Question

Whether the conversion of an existing retail unit to 2 no. one bedroom apartments is or is not development or is or is not exempted development.

No. 2 South Quay, Arklow, Co. Wicklow.

39/19

PROPOSED FRONT ELEVATION (NORTH)

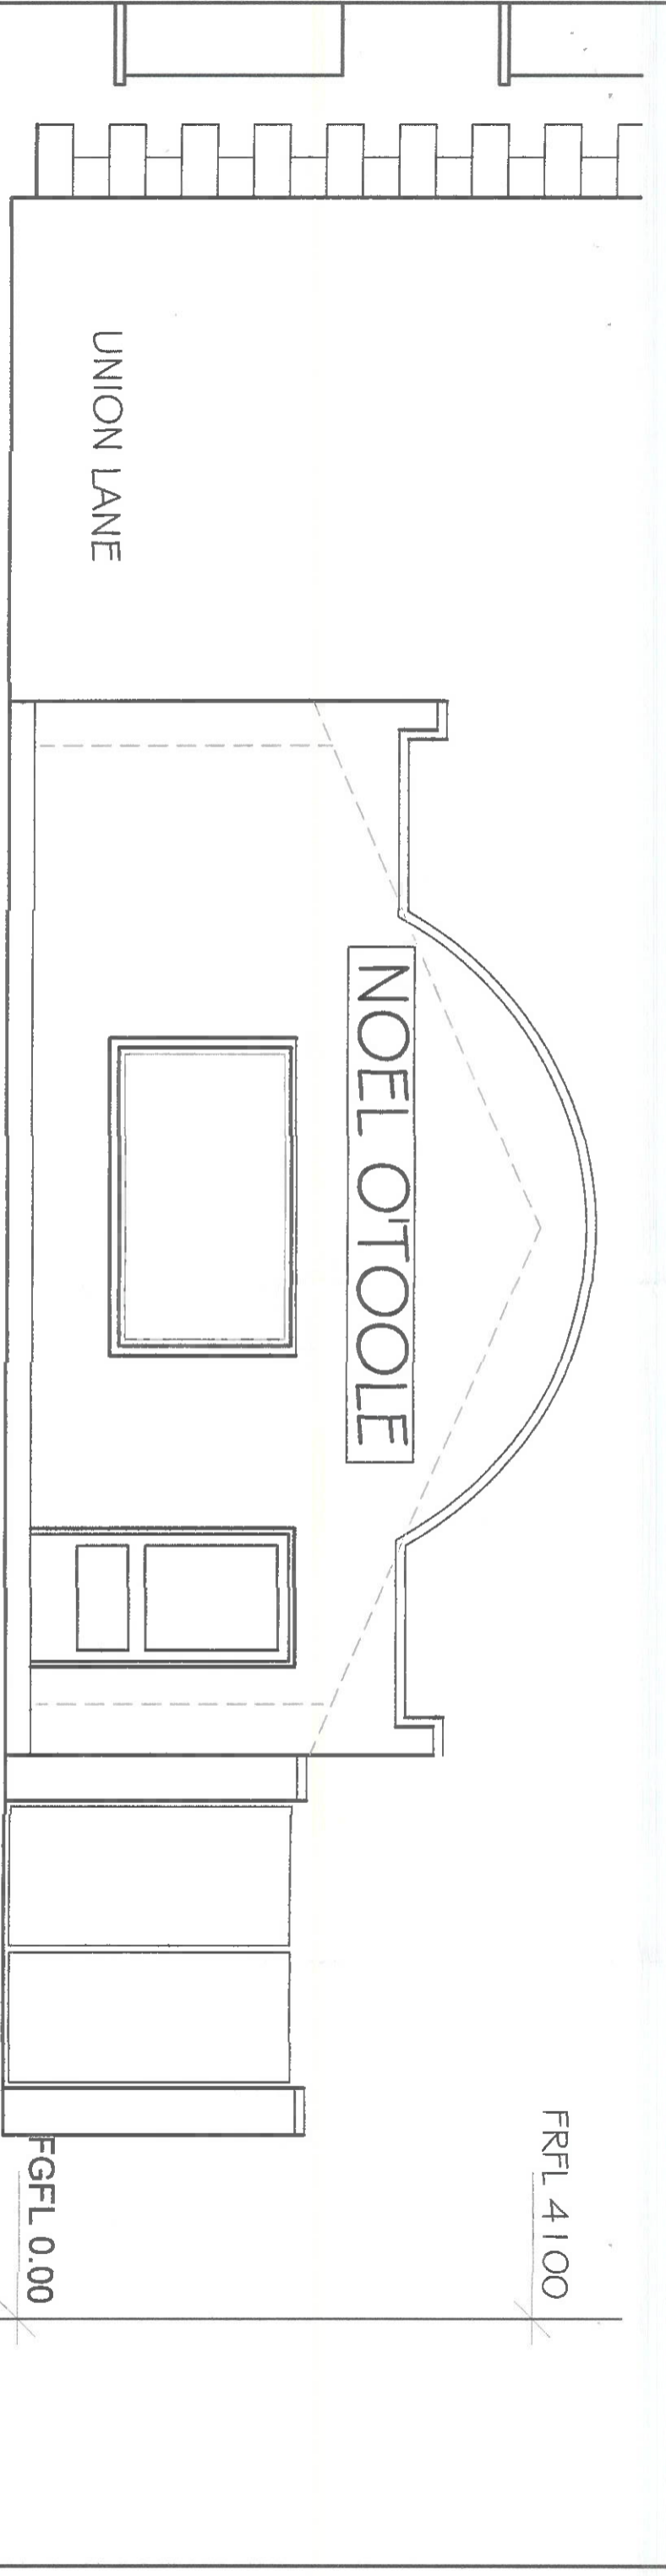
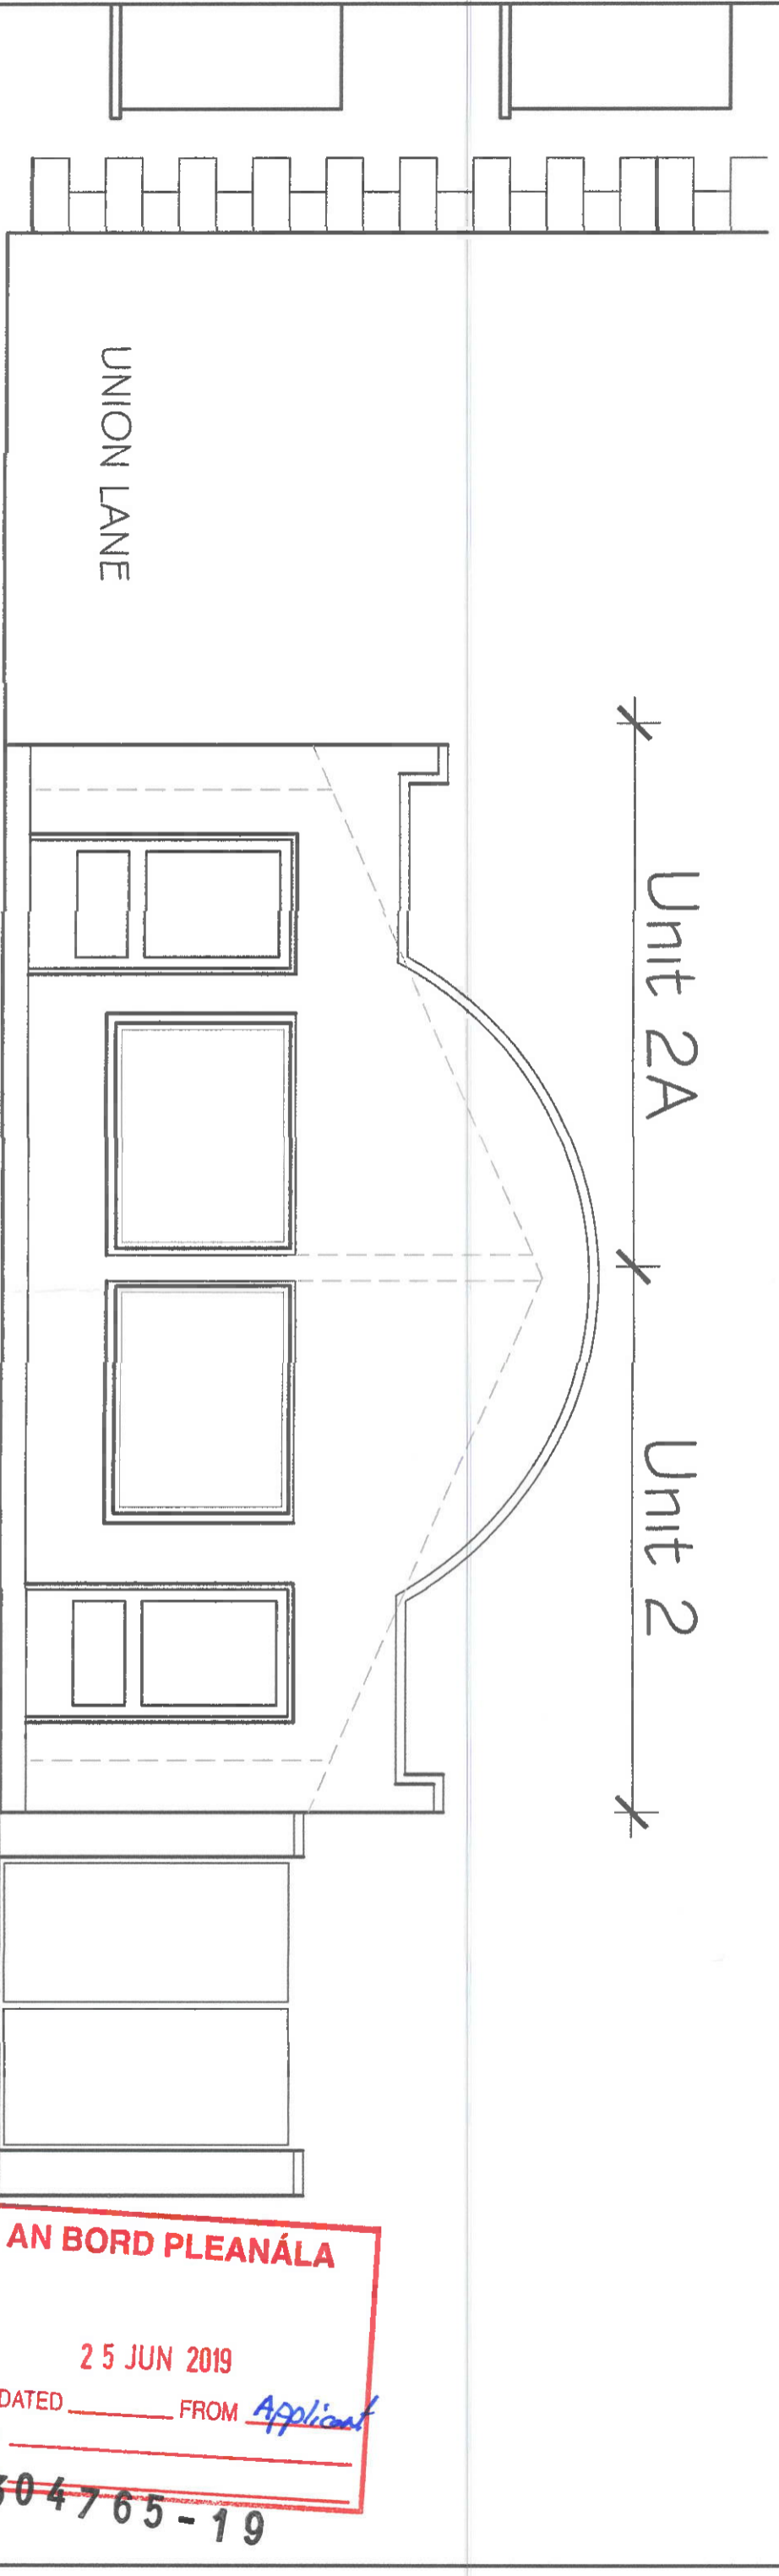
- 8.3.2. I agree with the Case Planner that the alteration of the existing shop front is consistent with the fenestration details and architectural and streetscape character of the remainder of the structure.

# PROPOSED GROUND FLOOR PLAN

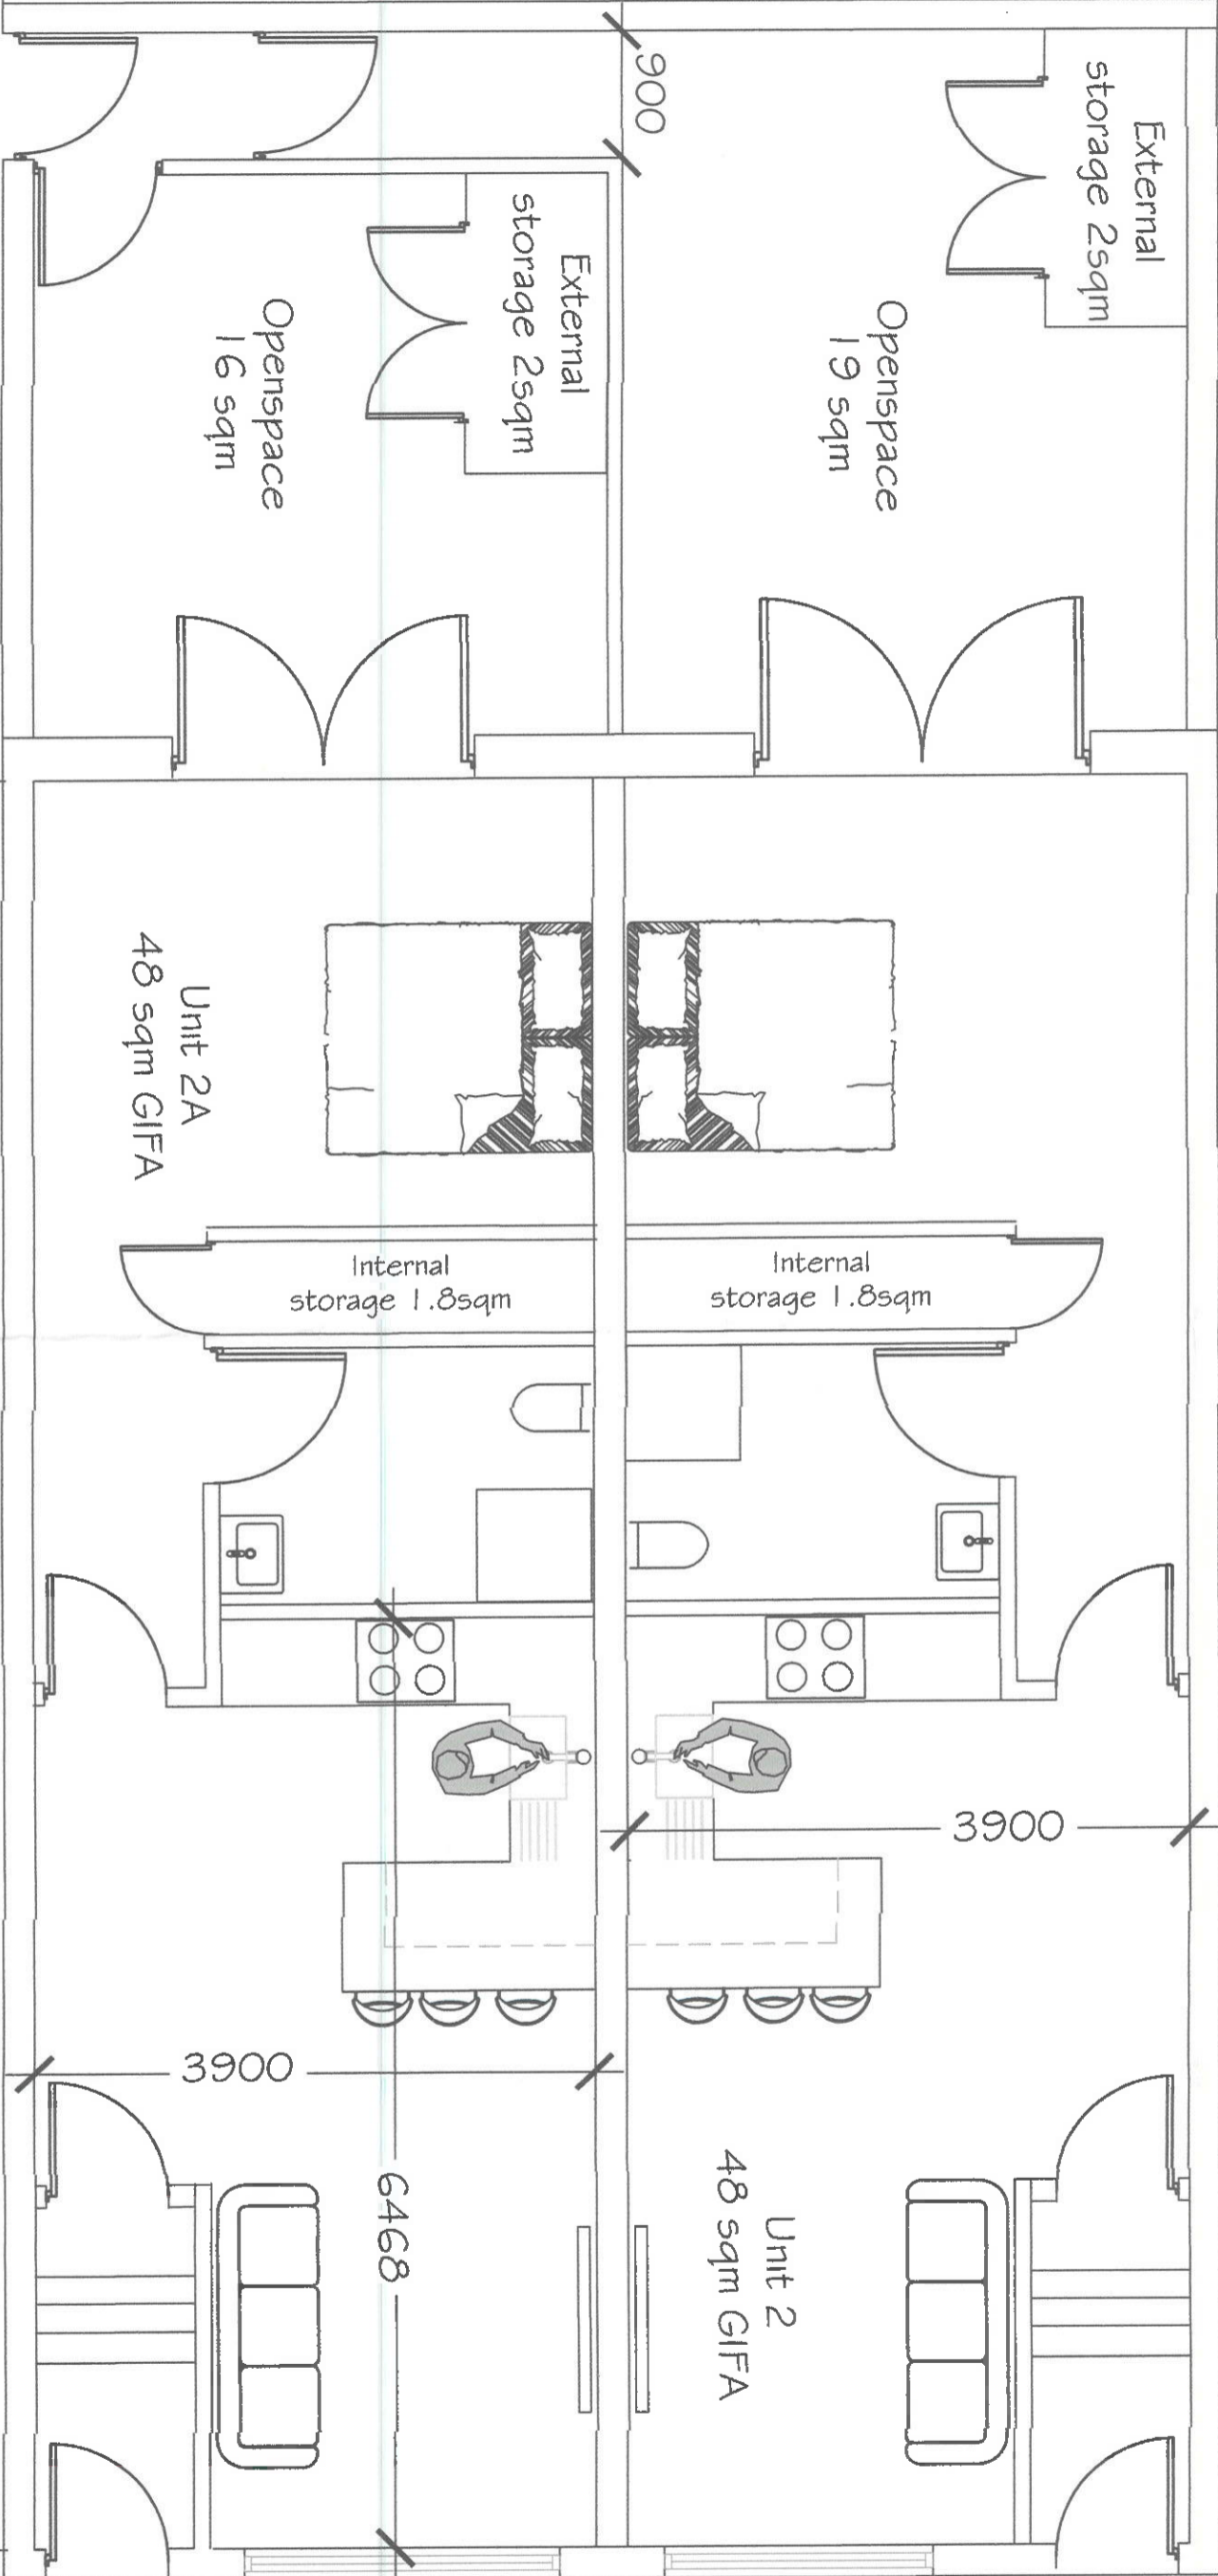
- 8.3.3. The works proposed in relation to the provision of open space to the rear of the property whereby the remainder of the main roof profile will be maintained are not considered to materially affect the external appearance of the structure so as to render its appearance inconsistent with the character of the structure or of neighbouring structures.

- 8.4.3. Storage Area – Article 10 (6)(d)(vi) requires that floor areas and storage space complies with the minimum requirements as set out in the Sustainable Urban Housing Design Standards for New Apartments – Guidelines for Planning Authorities. The amended plans and particular submitted with the referral comply with these Guidelines in terms of overall floor area, room widths and bedroom floor area. In terms of storage the revised plans provide 1.8sqm internally with the 2sqm externally for each unit. This is in excess of the 3sqm required by the Guidelines. The provisions of Article 10(6)(d)(vi) does not therefore apply.

- 8.4.4. Natural Lighting - Article 10 (6)(d)(vii) requires that rooms for use, or intended for use, as habitable rooms shall have adequate natural lighting. The units are dual aspect. Adequate natural light is available. The provisions of Article 10(6)(d)(vii) does not therefore apply.
